URBAN DESIGN BRIEF

1052 ST LAURENT BOULEVARD
5 SEPTEMBER 2025

RESPONSE TO URBAN DESIGN COMMENTS

URBAN DESIGN - COMMENTS ON PRELIMINARY DESIGN

1 WEST ELEVATION
A201 SCALE: 1 : 200

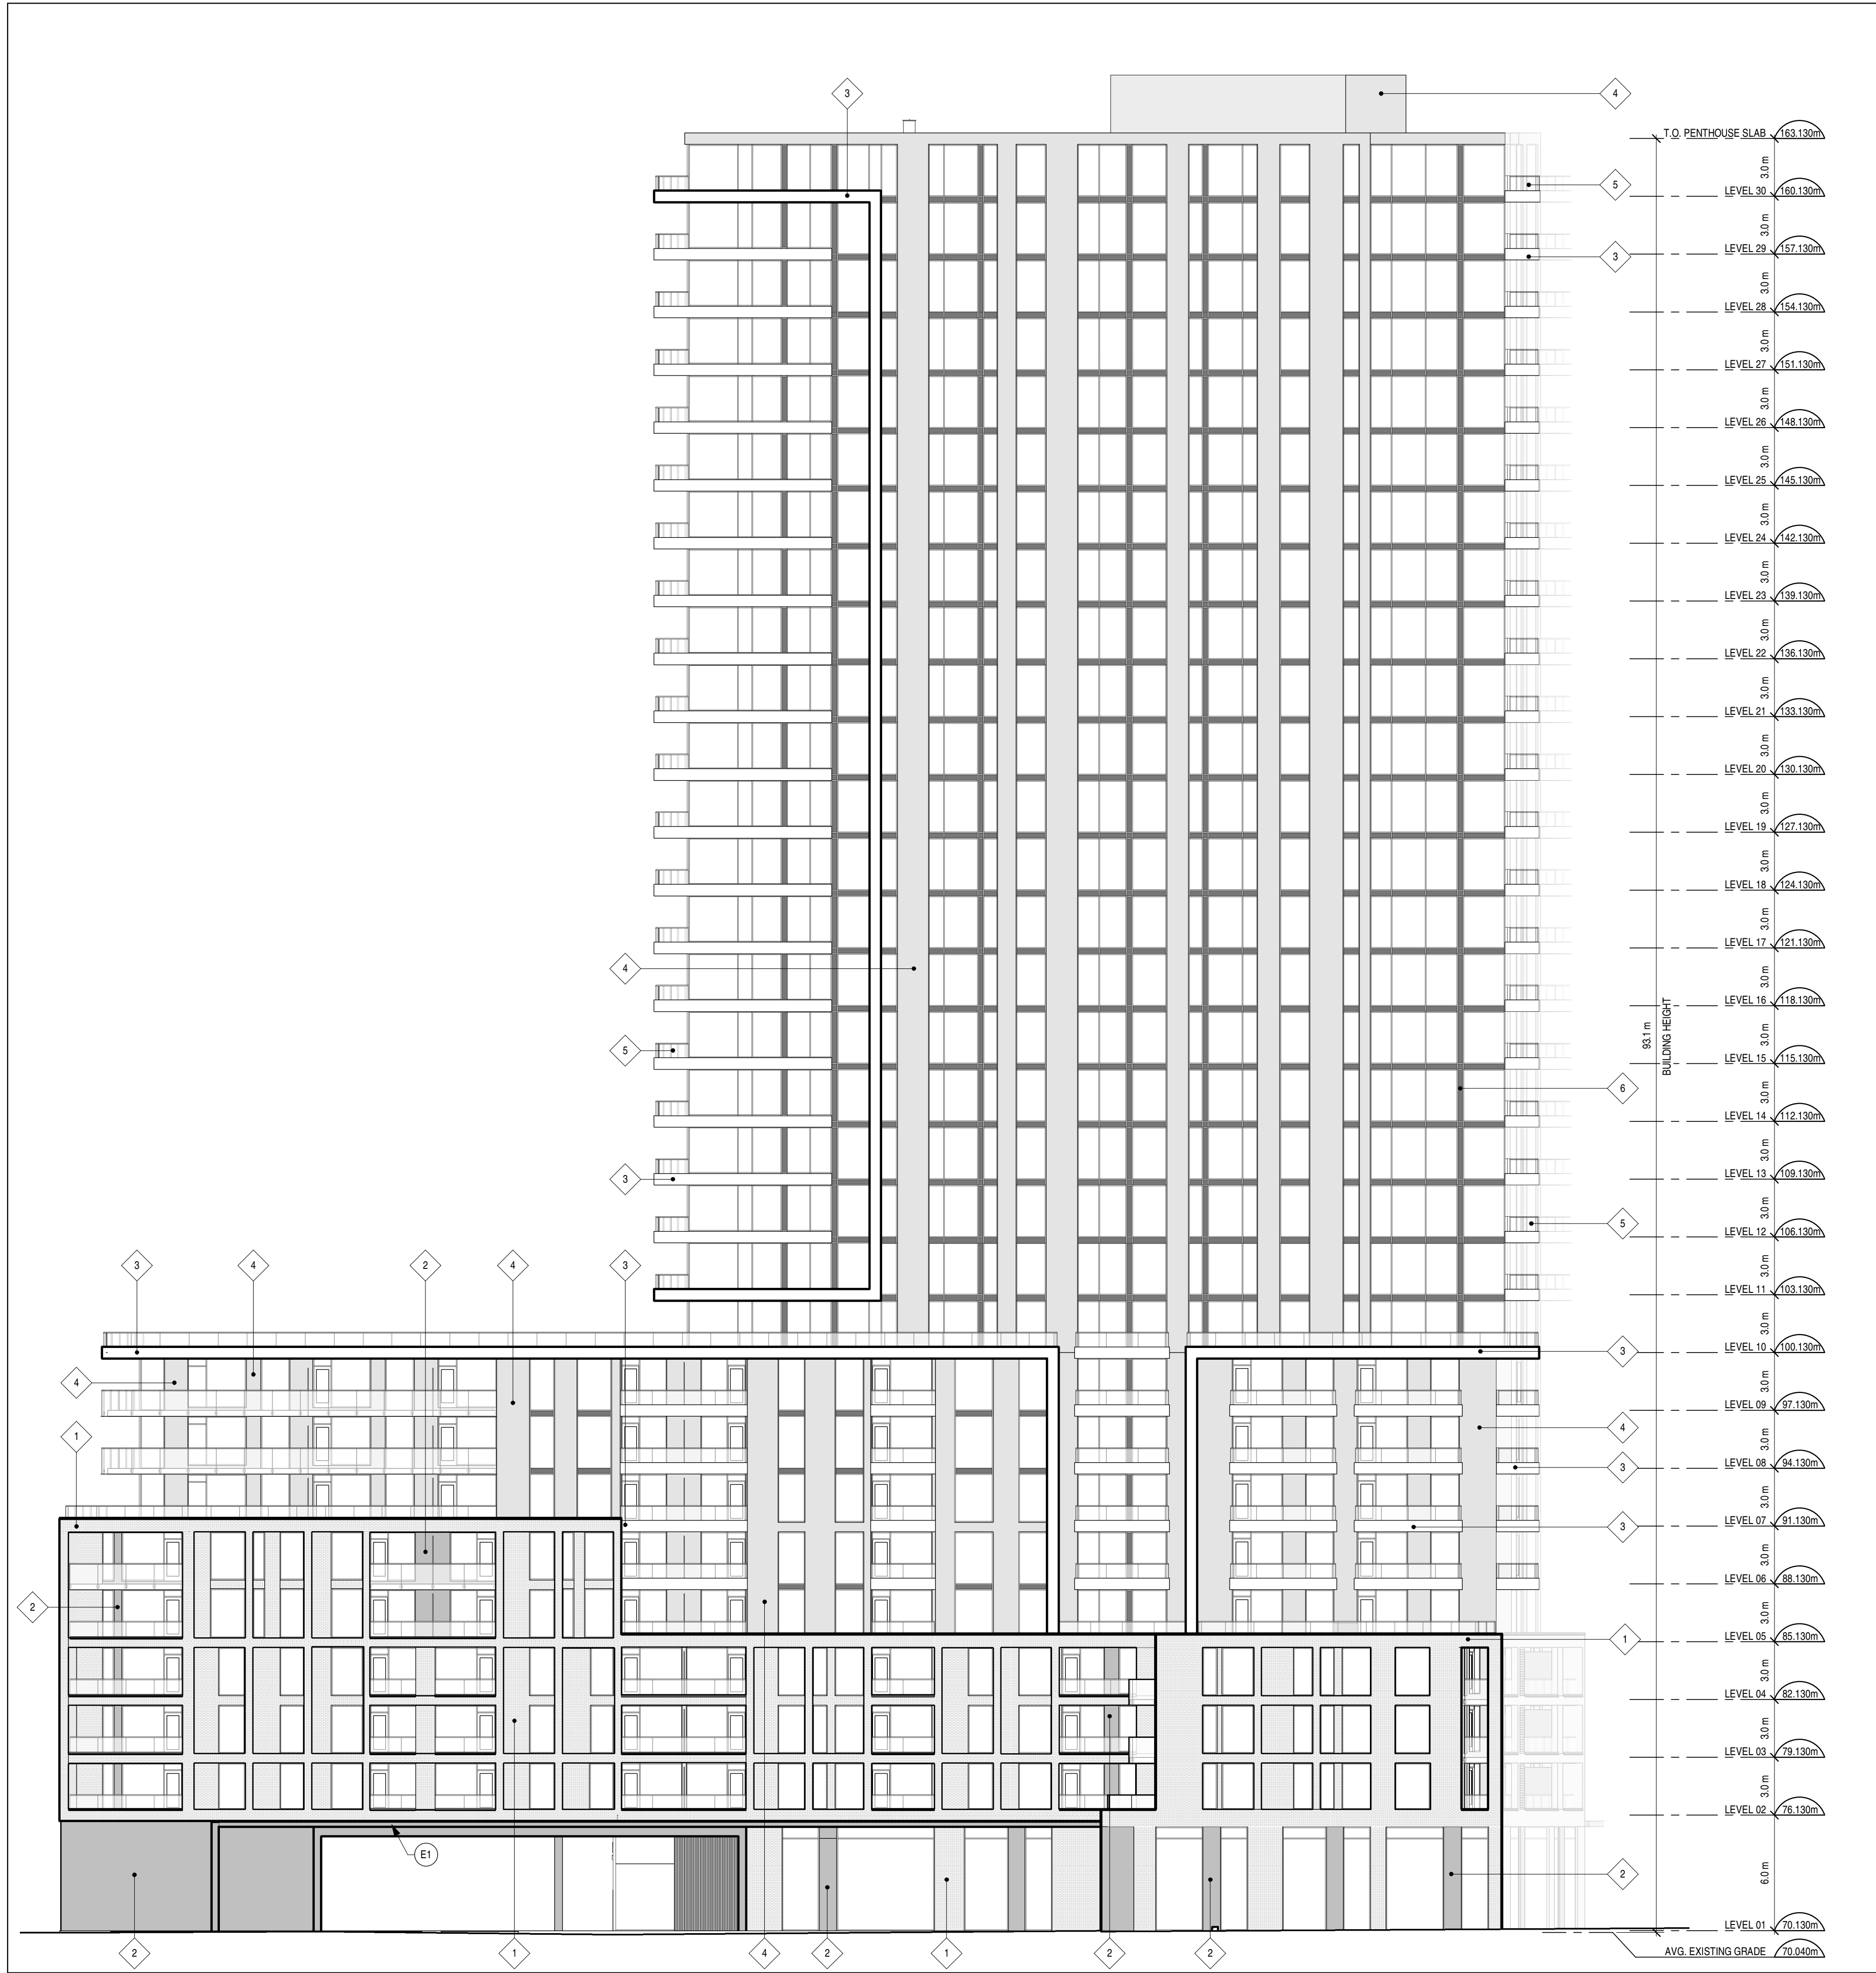
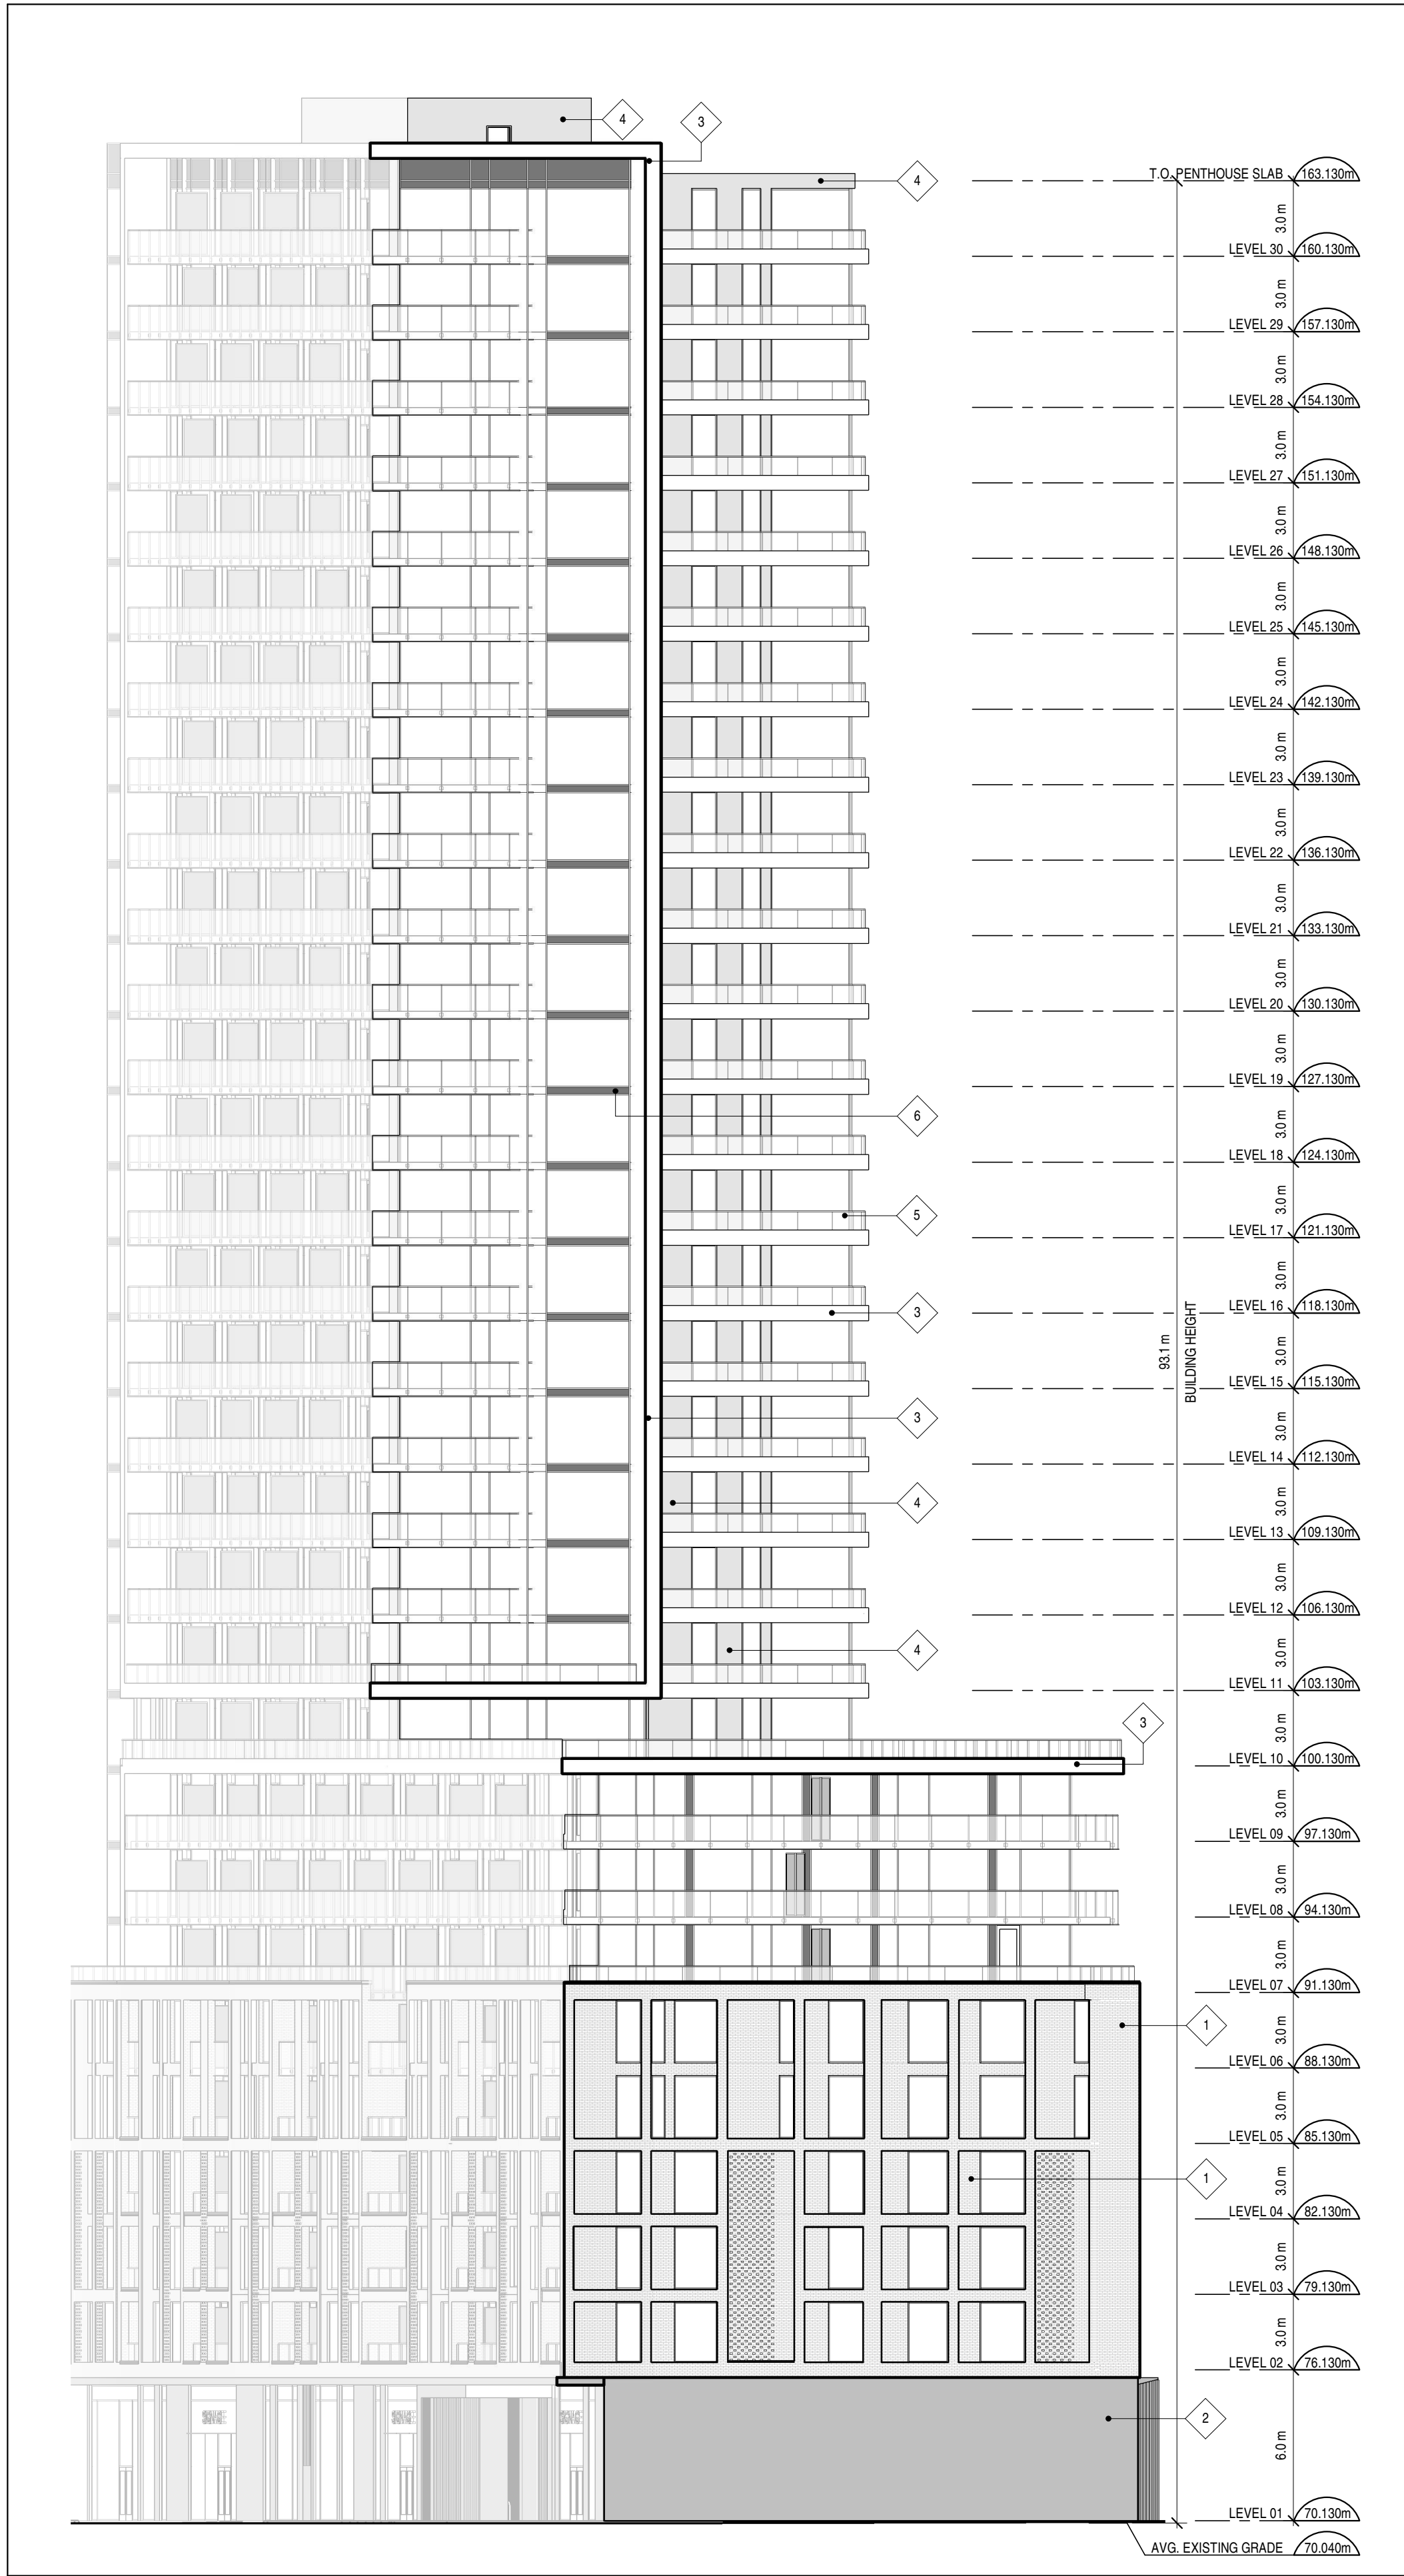
- The following element of the preliminary design are of concern:*
- a. Regarding OCH lands, modeling and a site section including the residential lands to the west would be helpful for us to have a fulsome conversation about transition and the impact of the massing on the surrounding contex*
Noted, Please refer to the section provided in this UDRP package on page 20.
